**Planning Application, Ribble Valley District
3/11/0859 The Old School House, Back Lane, Grindleton**

I refer to your letter of 14 November 2011 concerning the above application

Ground Floor Plan

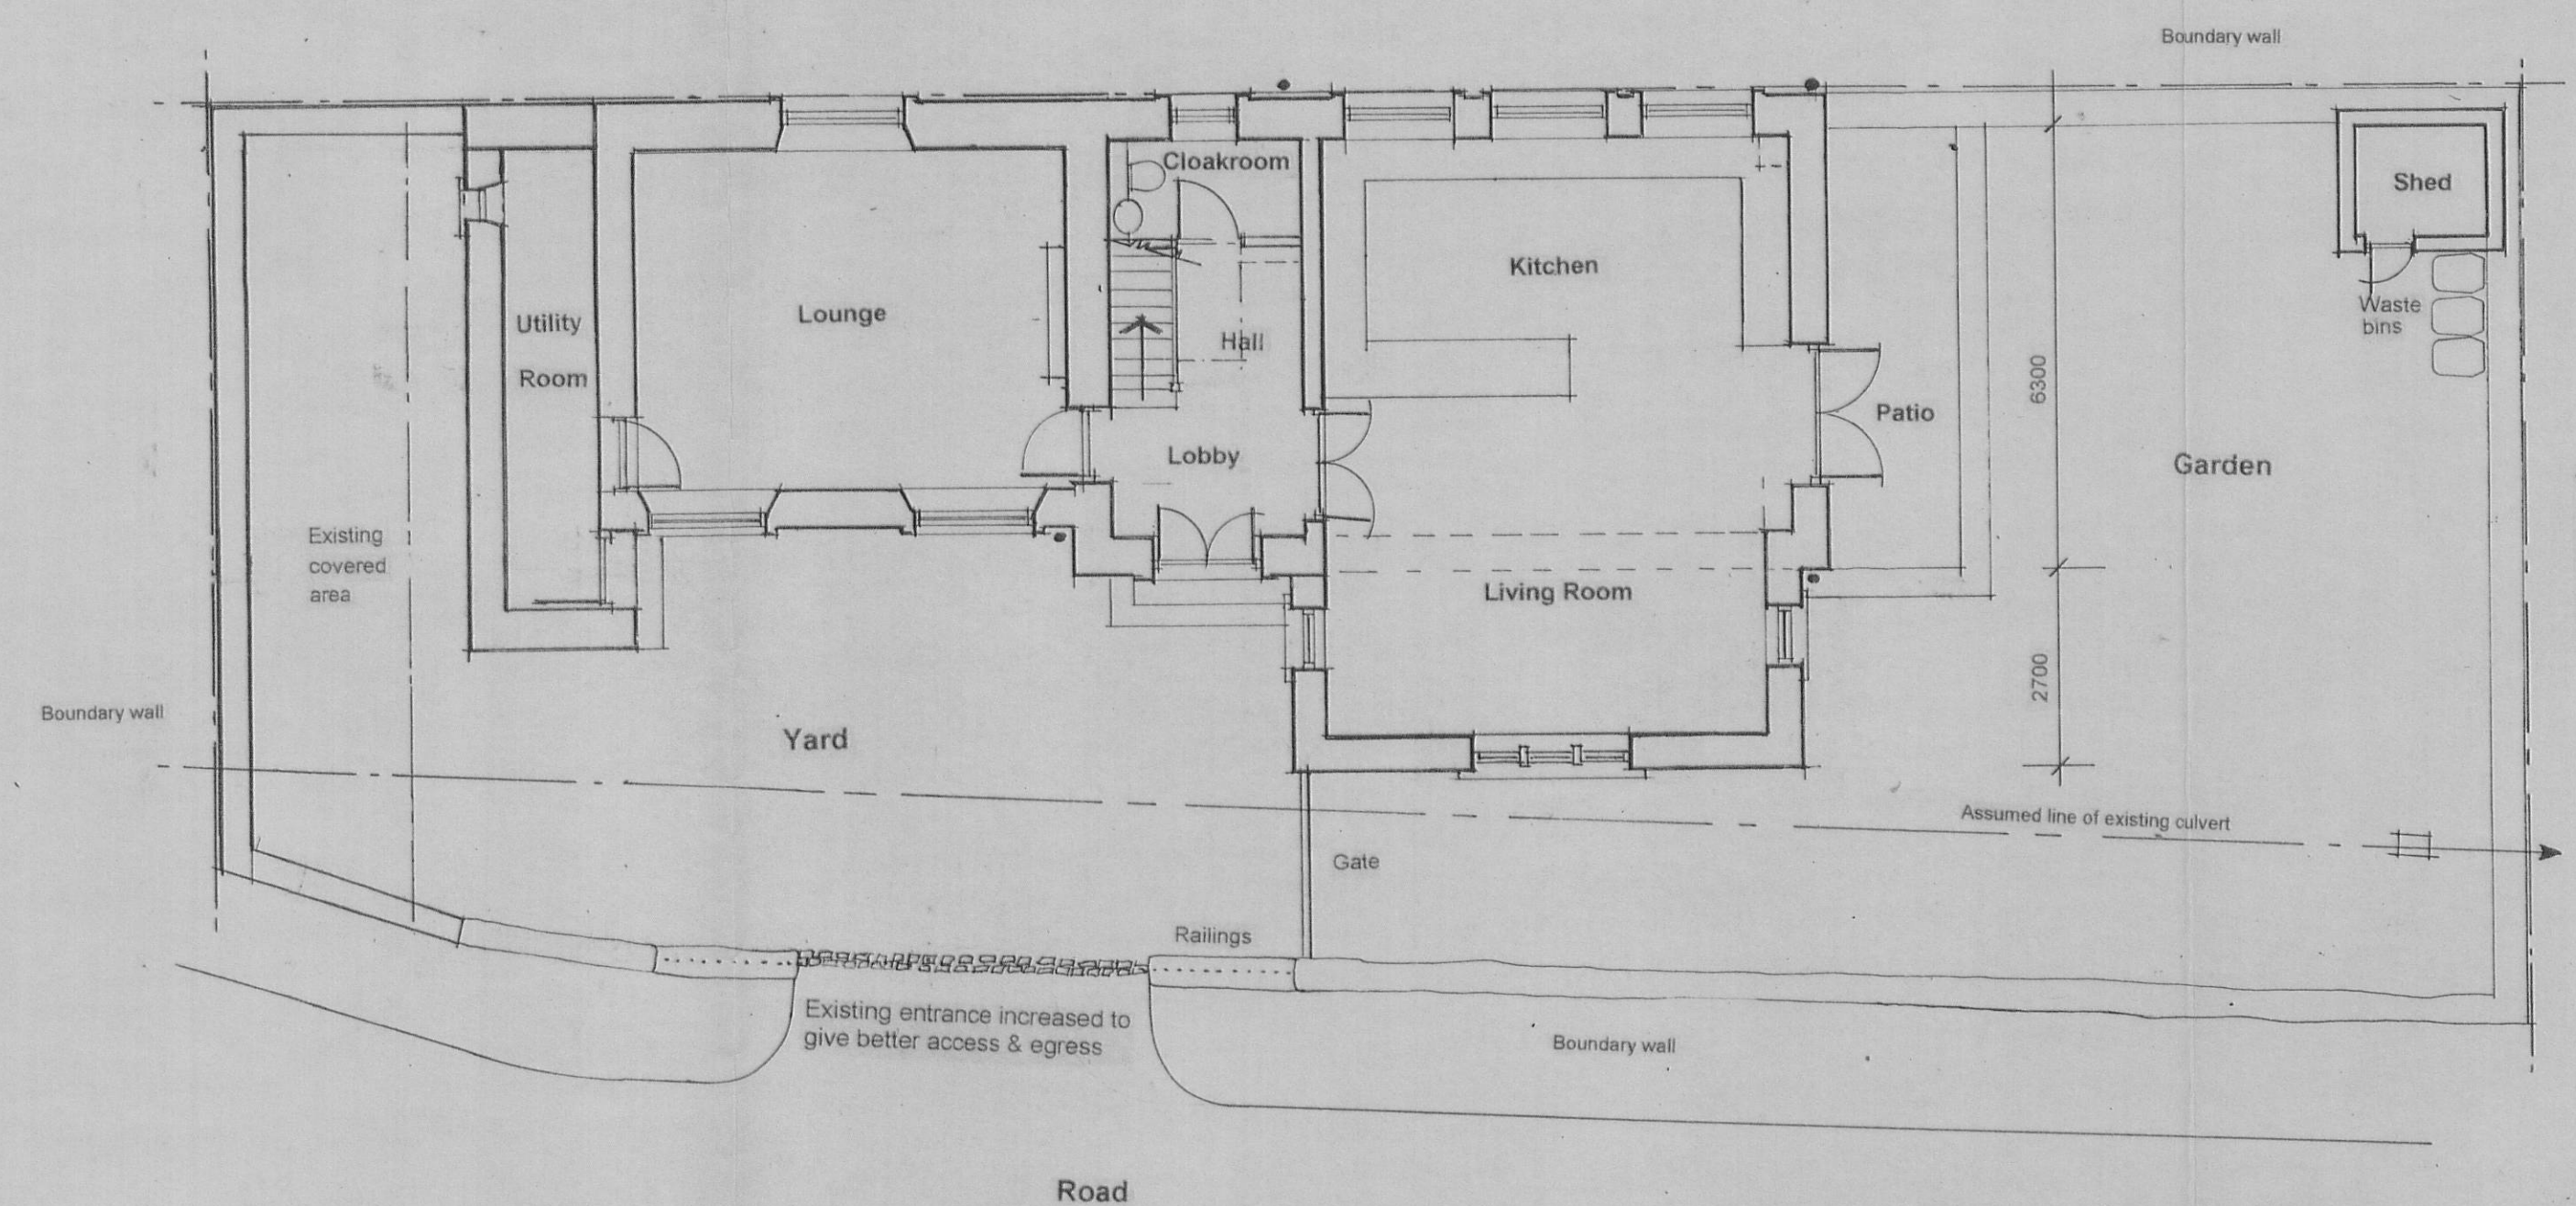
I have no objections in principle to the revised application on highway safety grounds

The alterations that are proposed to the vehicular access will be beneficial in securing a safe means of access to the site, both in terms of its location in respect of the junction with Smalden Lane and the increased entrance width to the site.
